From: Judith Ward
Sent: 08 August 2018 12:10
To: Emily Shaw
Subject: 18/00168/DISC Site D and E Graven hill

Judith Ward
Landscape Planning Officer
Cherwell District & South Northants Councils

Detail D , 1:100

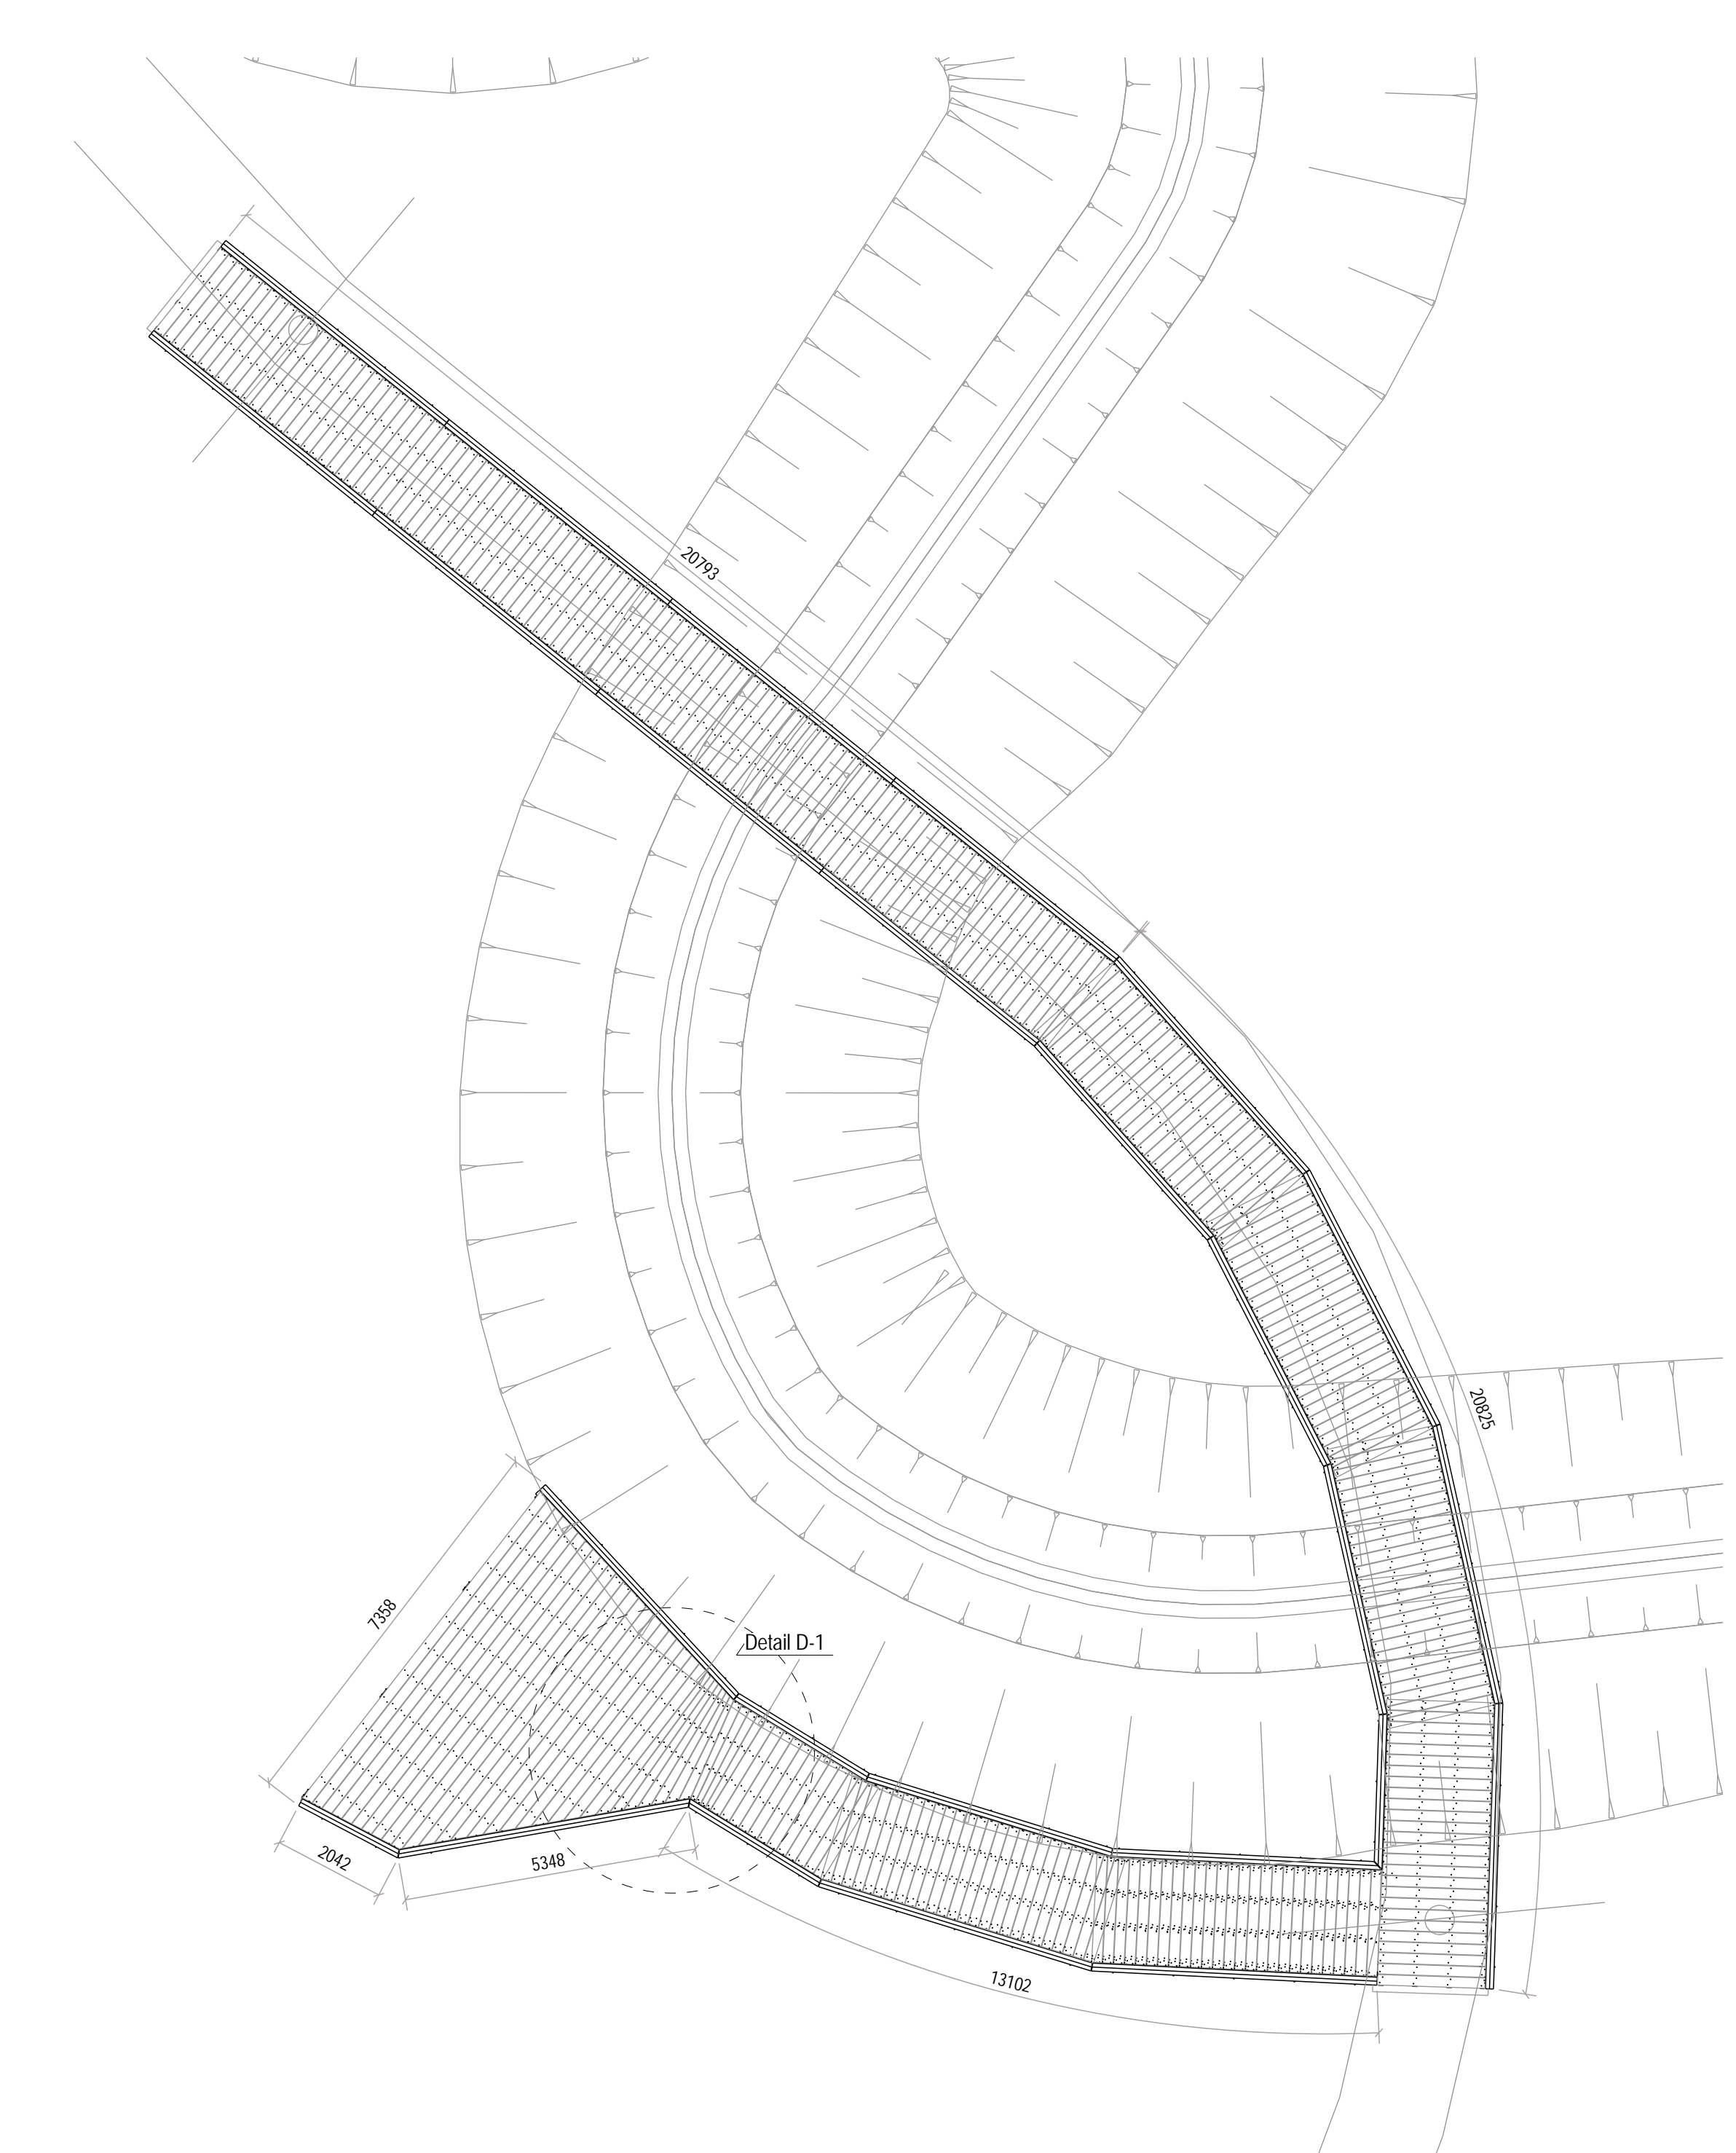
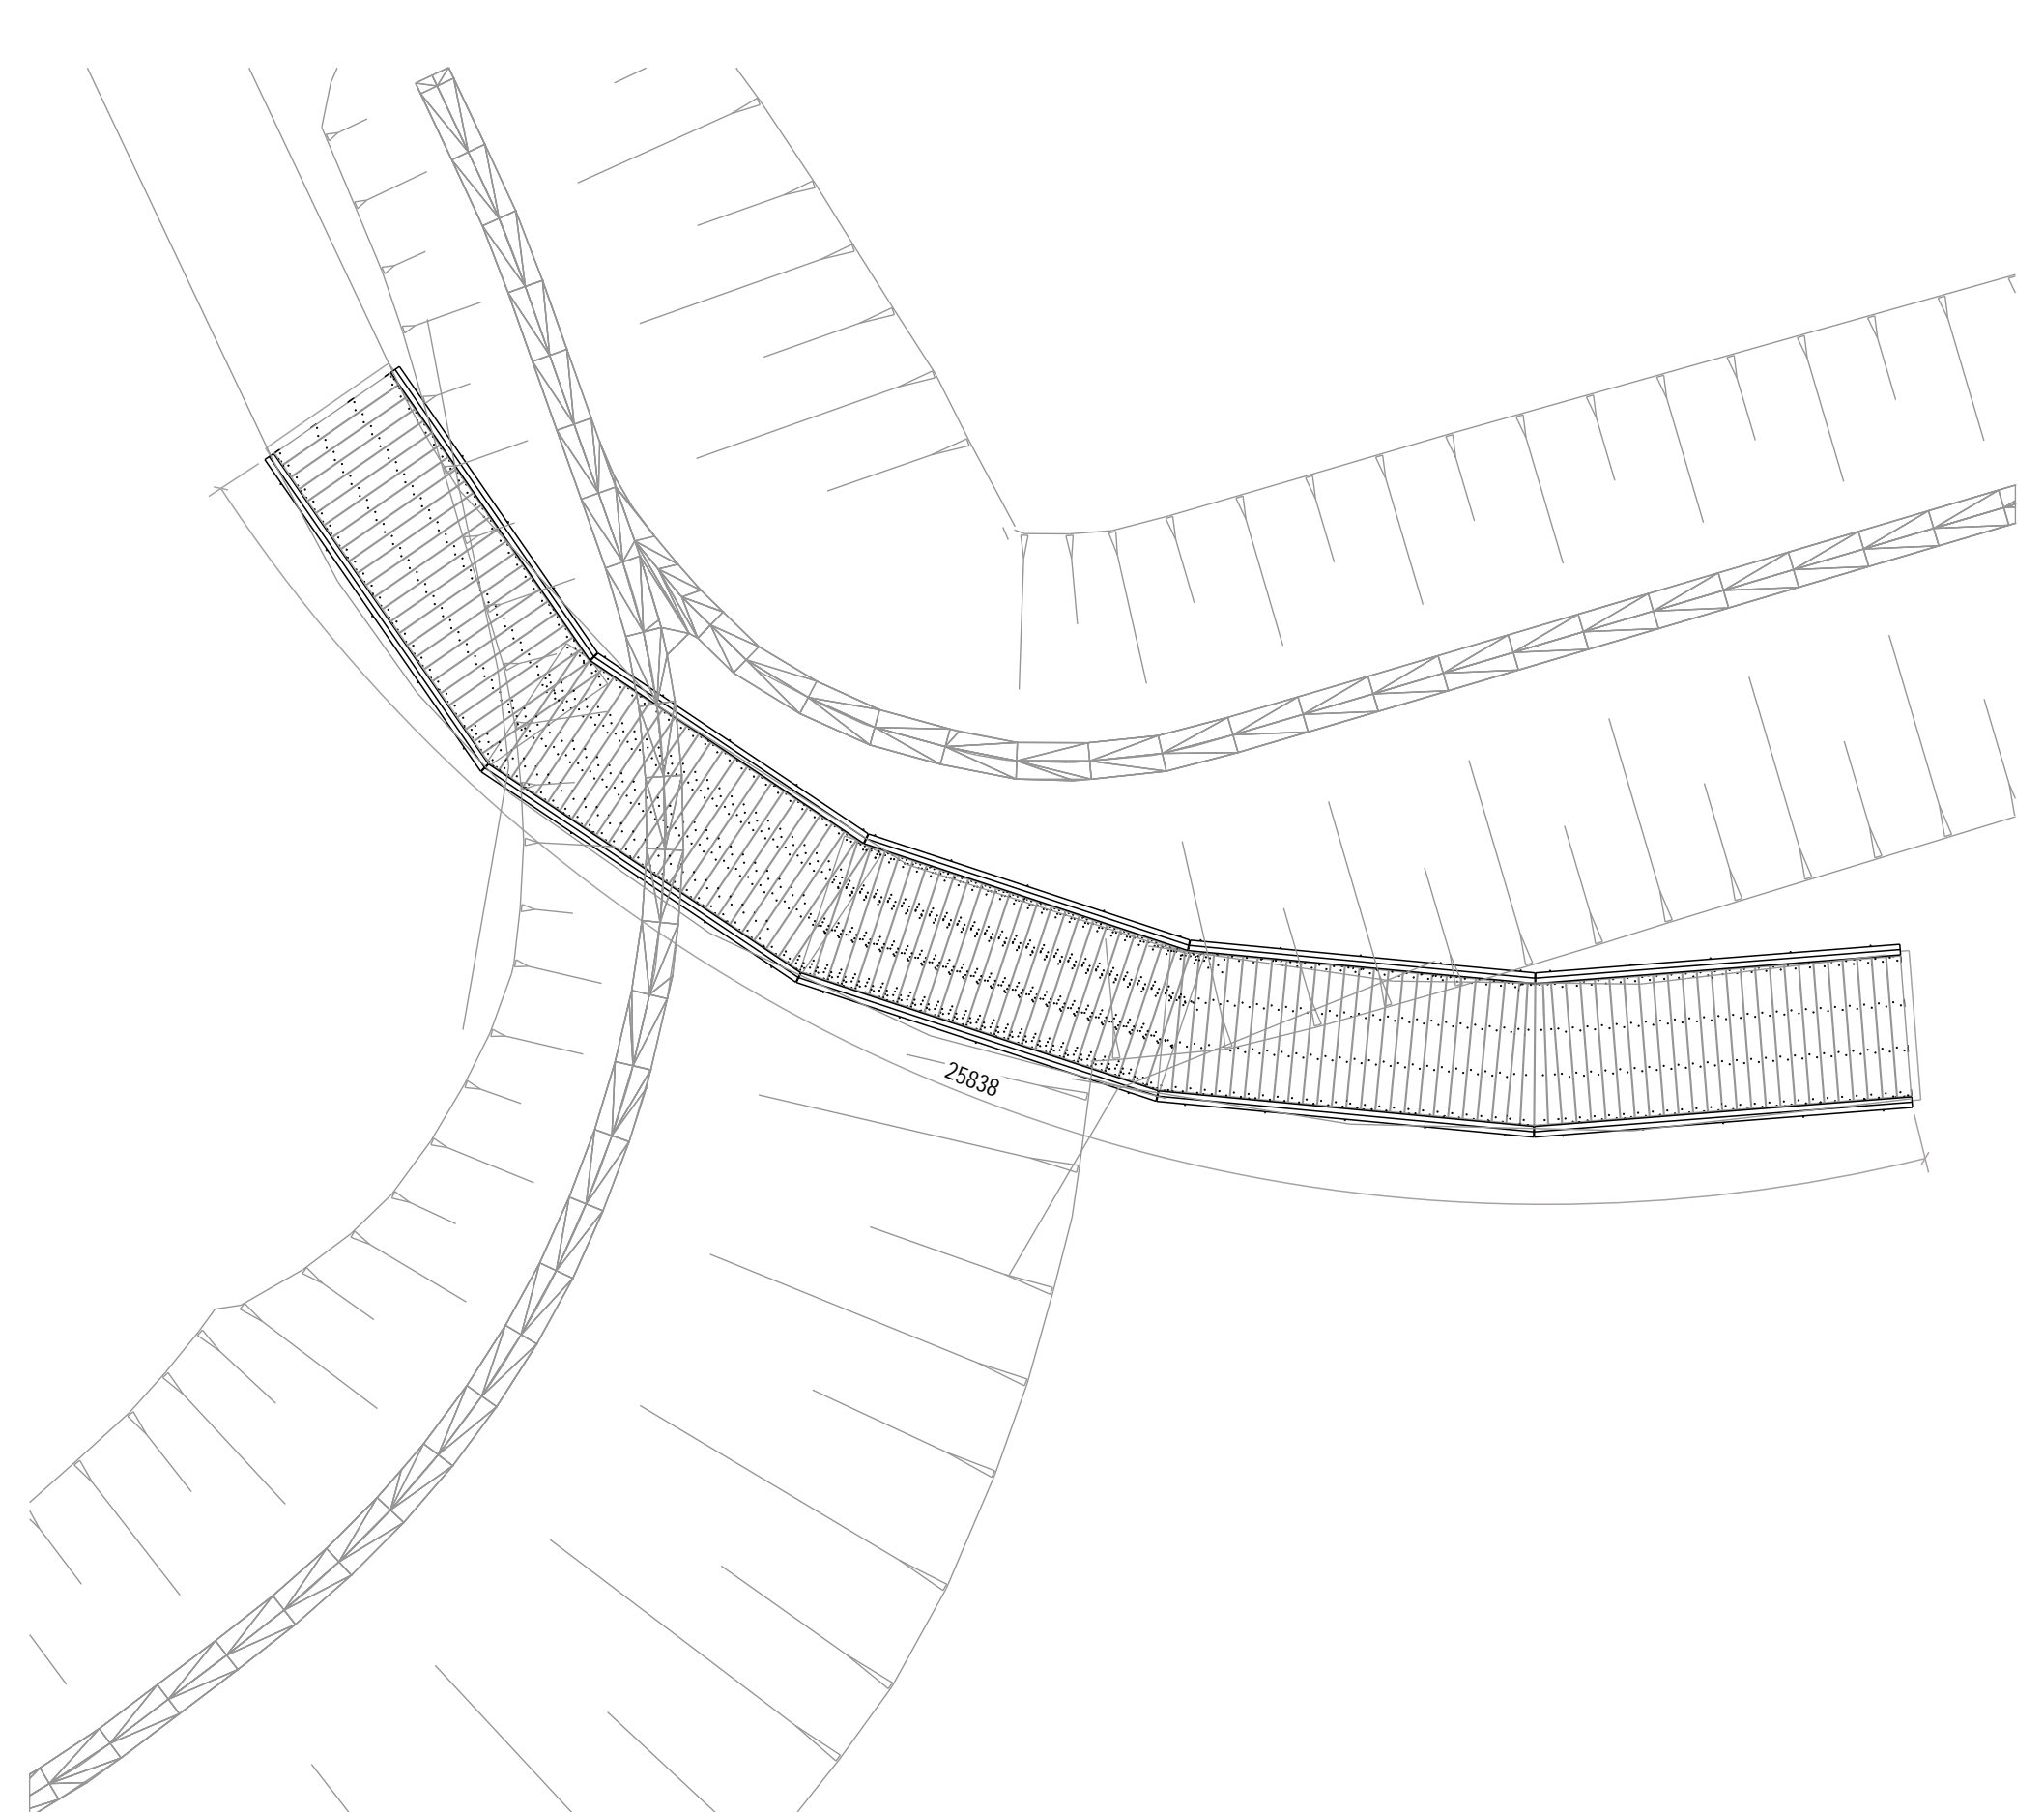
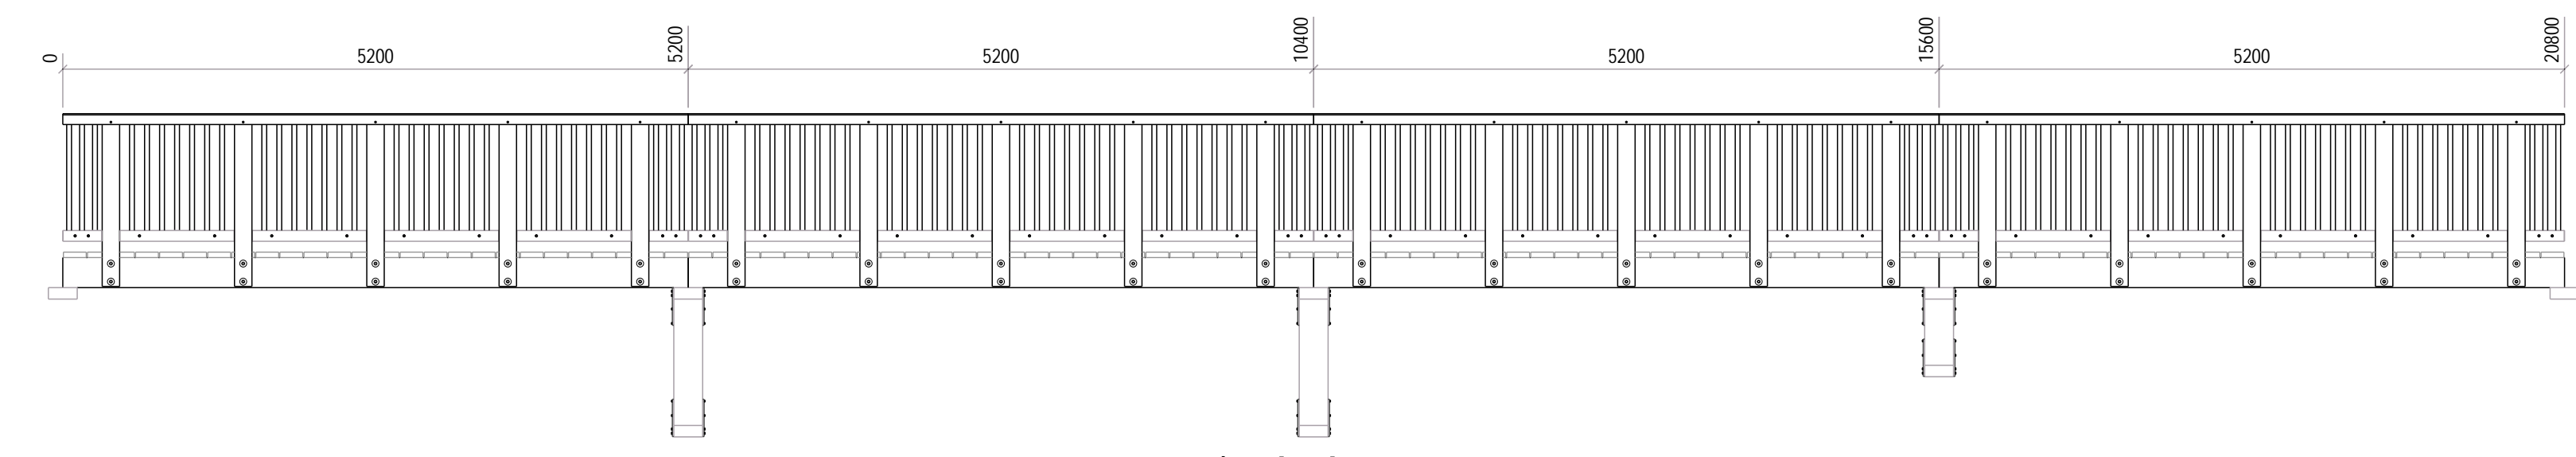
Condition 9. The timber bridge and walkways are acceptable.
